November 13, 2001

Re: Darco Products Grading & Drainage Plan, Engineer's stamp dated ^{11 nm}10-07-01 (C17/D1CC)

Re: Traffic Circulation Layout (TCL) Submittal for Building Permit Approval for
Darco Products Inc., [C17 / D01CC]
8406 Washington Pl. N.E.
Engineer's Stamp Dated 01/11/02

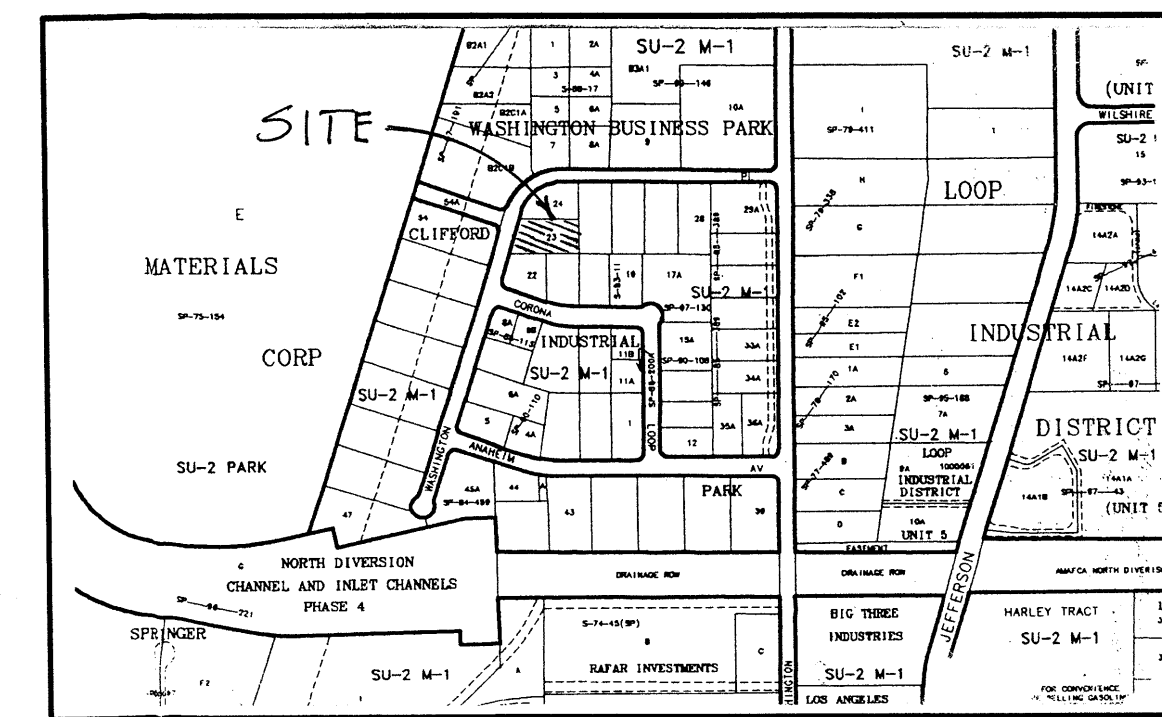
- Please correct the Project BM. On the original G&D plan for this site (dated 1987), the elevation is given as "87.65," and in your current submittal, the elevation is given as "87.43."
